**From:** [Wolfenbarger, Jeanne](#)  
**To:** "Ryan Mulhall"; [Regina Okoye](#); [Al-najjar, Marwa G.](#); [Rodenbeck, Jay B.](#)  
**Subject:** RE: Plat for Champion 4th Street / [PR-2021-006366] ready for DRB signatures  
**Date:** Friday, May 27, 2022 10:04:51 AM

Good morning Jay, I've attached the necessary proof of completion for the sidewalk of the plat to get our plat for Champion 4th Street / [PR-2021-006366] signed by Transportation. The other departments should have been able to sign already.

Sheet: **LANDSCAPE PLAN**

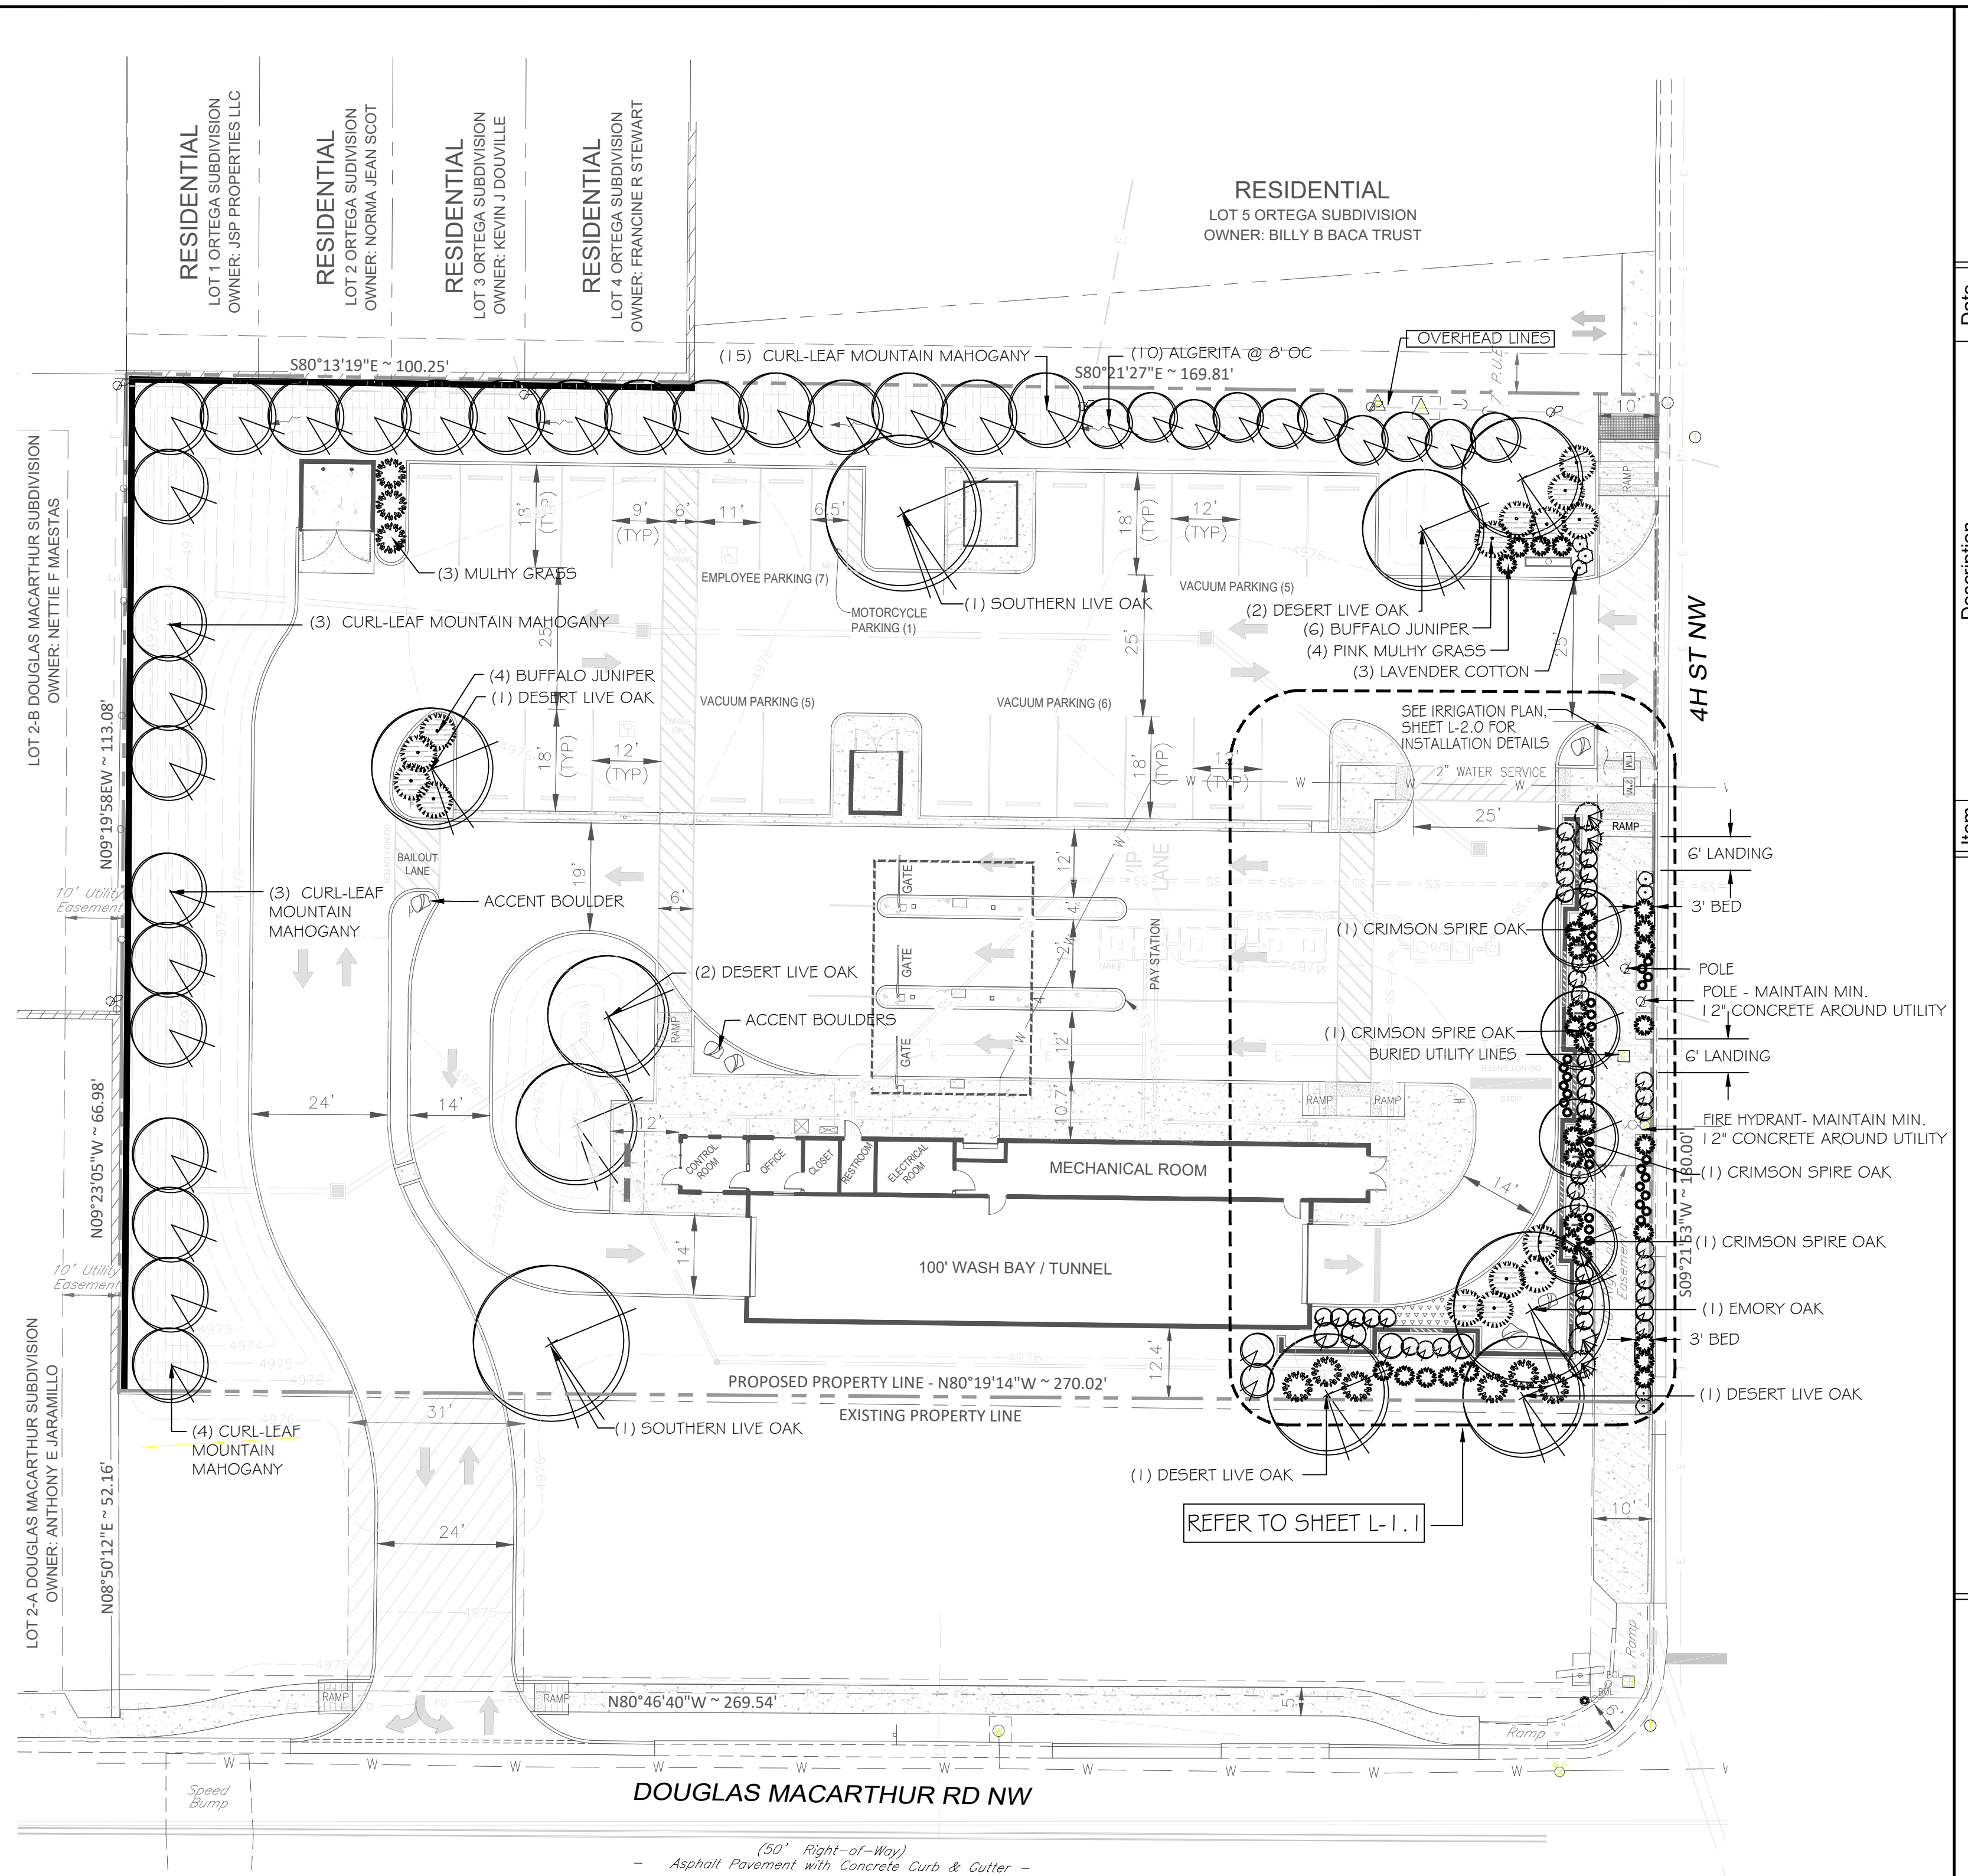
For the future, the site plan should show all of the existing sidewalk dimensions along the frontage, and the site plan should also provide ADA-accessible drive entrances and close any existing driveways that will not be used. The yellow painting along the header curb at the back of the ramp can be refreshed at that time, and the detectable warning surface for that ramp should cover the entire width of the landing before crossing the street. (However, this can be a separate action as part of site plan approval.)

- Marwa Al-najjar is reviewing a site plan showing the sidewalk, and the correct dimensions should be shown on that plan as part of that action. One of the concerns I had was that the header curb at the back of the wheelchair ramp at Douglas MacArthur/4<sup>th</sup> Street should be painted yellow to prevent a tripping hazard.

**Plat for
Tracts A and B
Champion 4th Street
Being Comprised of
Lot 1, Block 2 of Douglas MacArthur
Subdivision and Tract 112-A-2
MRGCD Map 32
City of Albuquerque, Bernalillo County, New Mexico
February 2022**

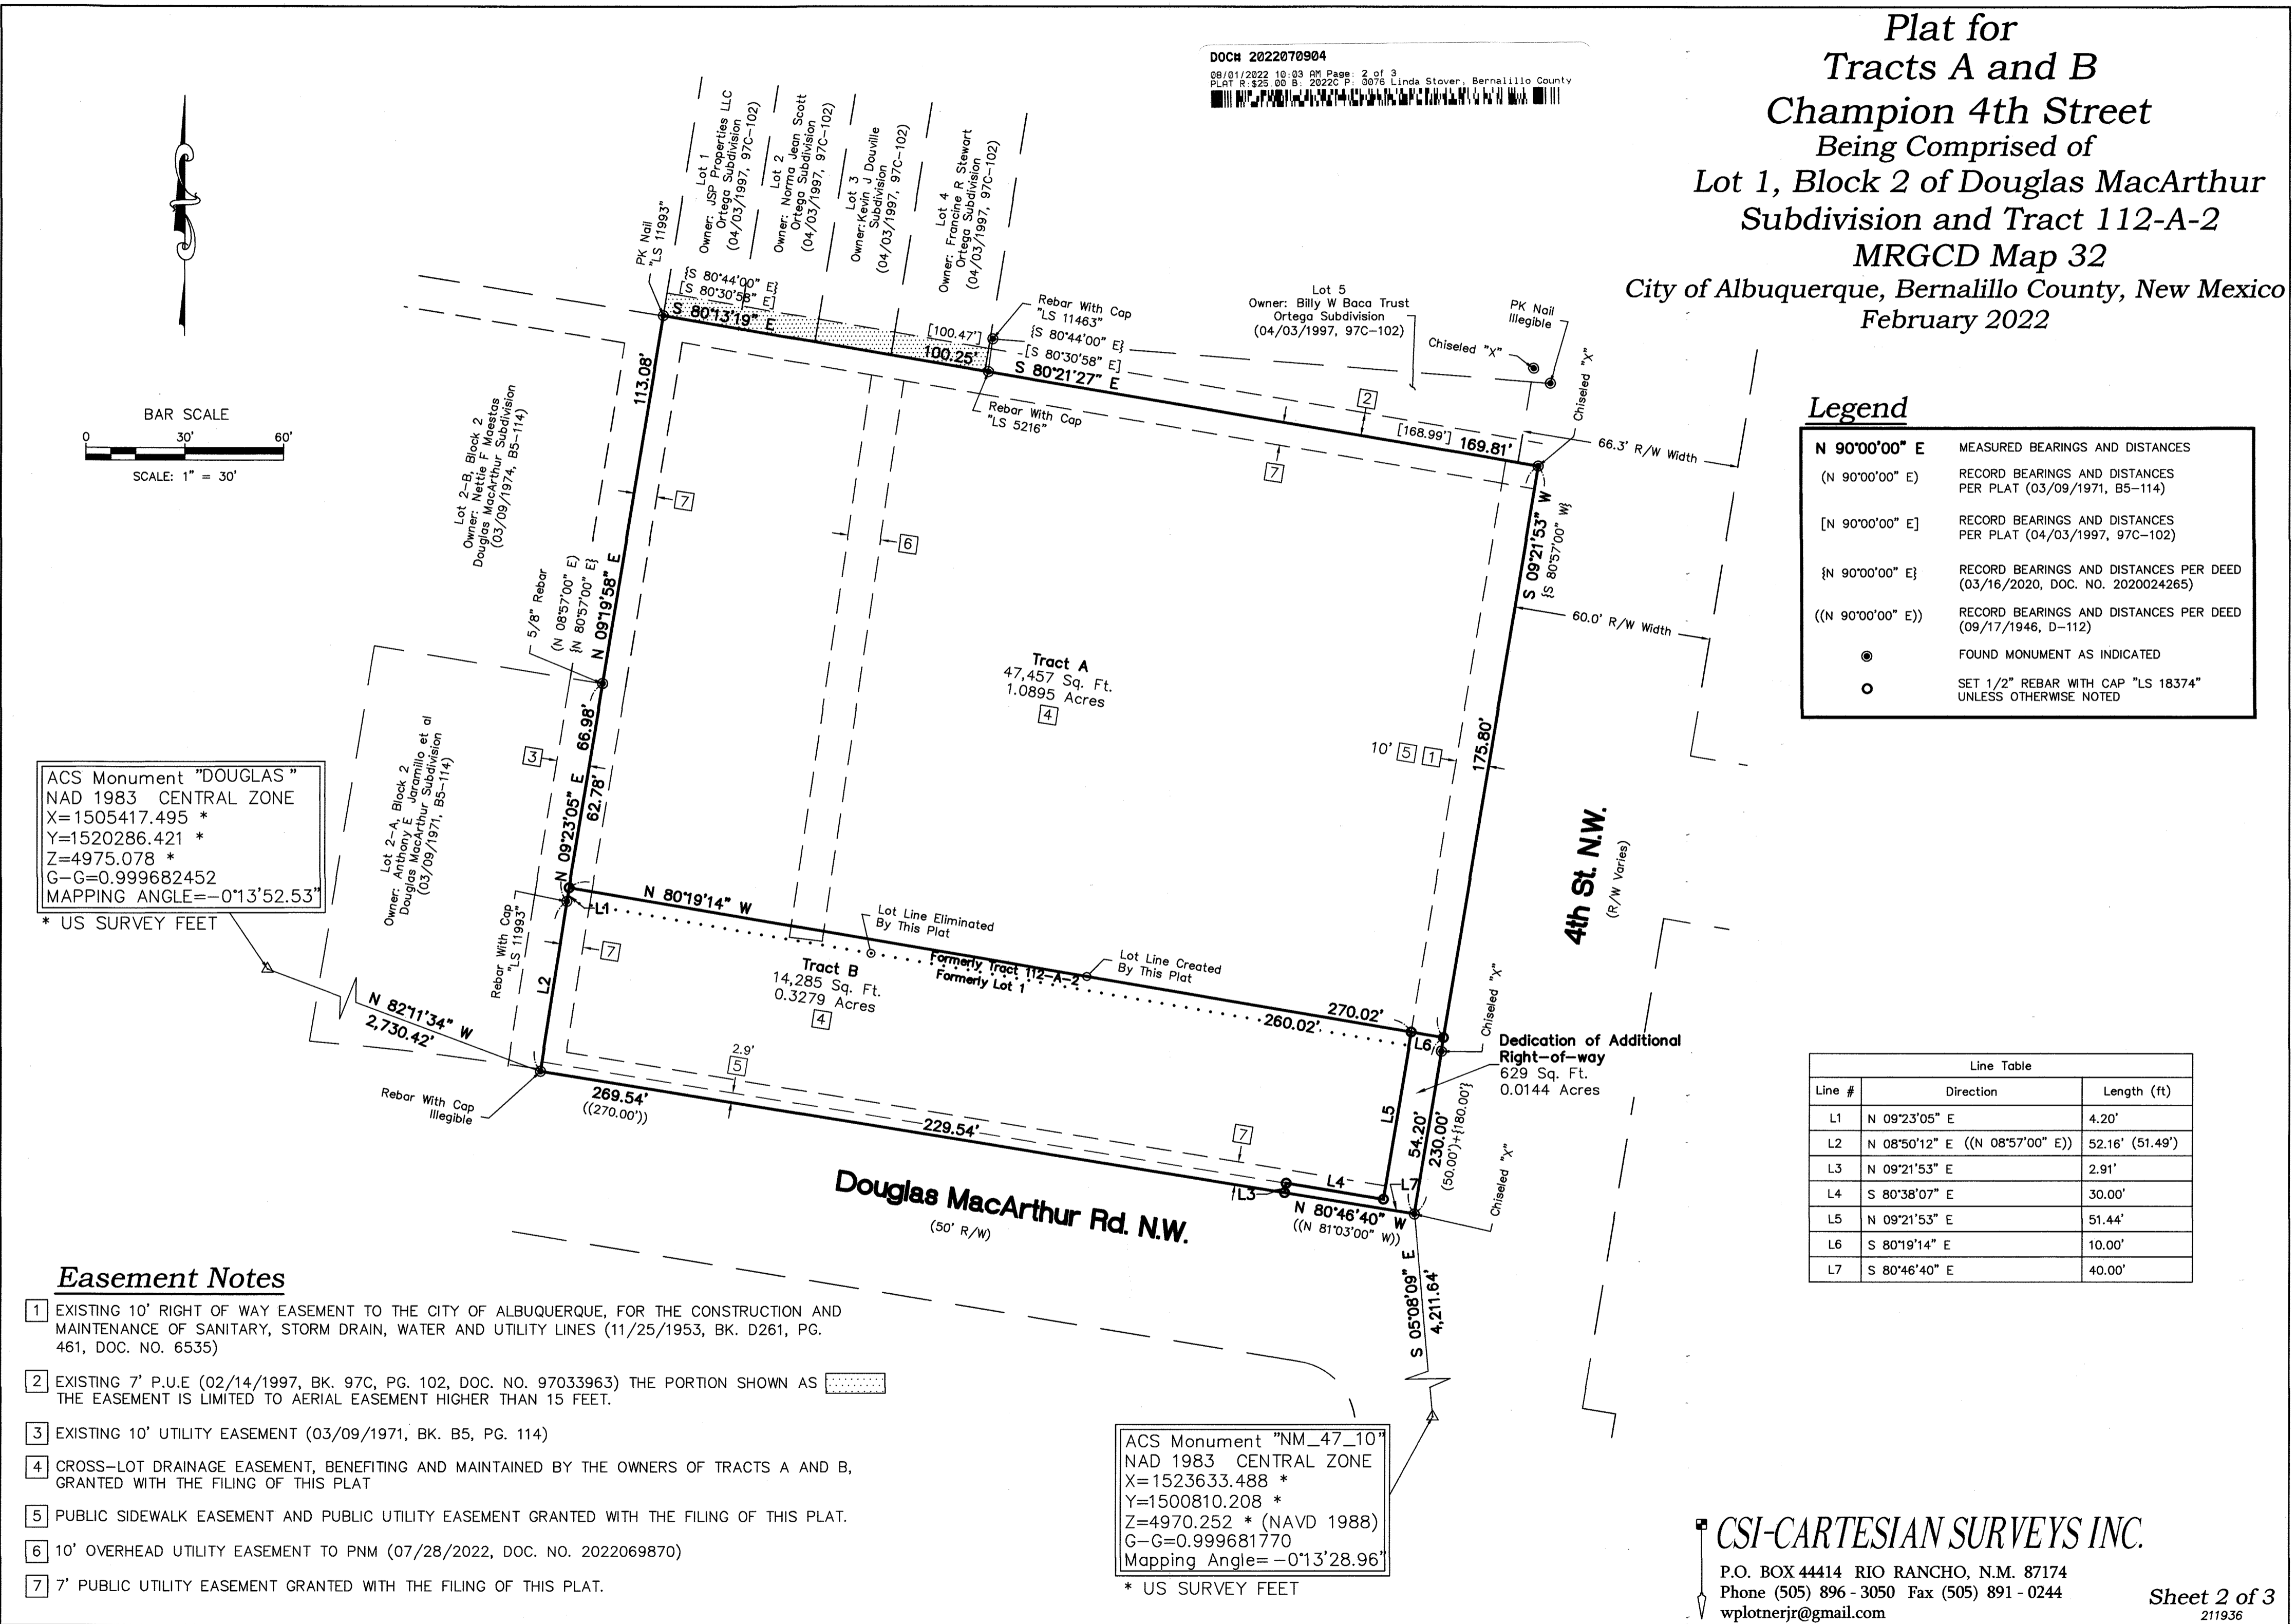
- I don't have anything that shows the 10-foot measurement on the 4<sup>th</sup> Street sidewalk or the five-foot measurement on Douglas MacArthur. (You sent two photographs but I could not tell where exactly that was located.) It has to be proven that

the five-foot sidewalk and 10-foot sidewalk are in place prior to the signing of the plat. I just need some confirmation.

Good morning Ms. Wolfenbarger, our runner was able to collect dimensions of the whole sidewalk widths. I've attached the photos in this email since thankfully they are much smaller in file size. The first photo is the 4th street sidewalk width at the hydrant, and you'll recognize the orange spotting paint should match the broader photos previously provided. The second photo is the width at the header curbing location, which you mentioned need to be painted yellow. The third photo is of the Douglas MacArthur sidewalk, near the driveway under the shade trees there. Charlie mentioned there was a lady inspector for the city there when he was taking his photos and she was satisfied with his photos and measurements.

The pictures were taken by the paving company, and are showing the new addition of sidewalk only, so the 4 ft 11 inches foot additional sidewalk measurement confirmed the new pad widths, which were added to the existing 6.1 foot sidewalk to make the 10 foot along 4th street. There is one photo with some greenery and shade that should be the new Douglas MacArthur sidewalk shot, since there aren't trees along 4th. I realize we don't have a clear dimensioning photo along that portion, just the photo highly focused on a concrete pad.
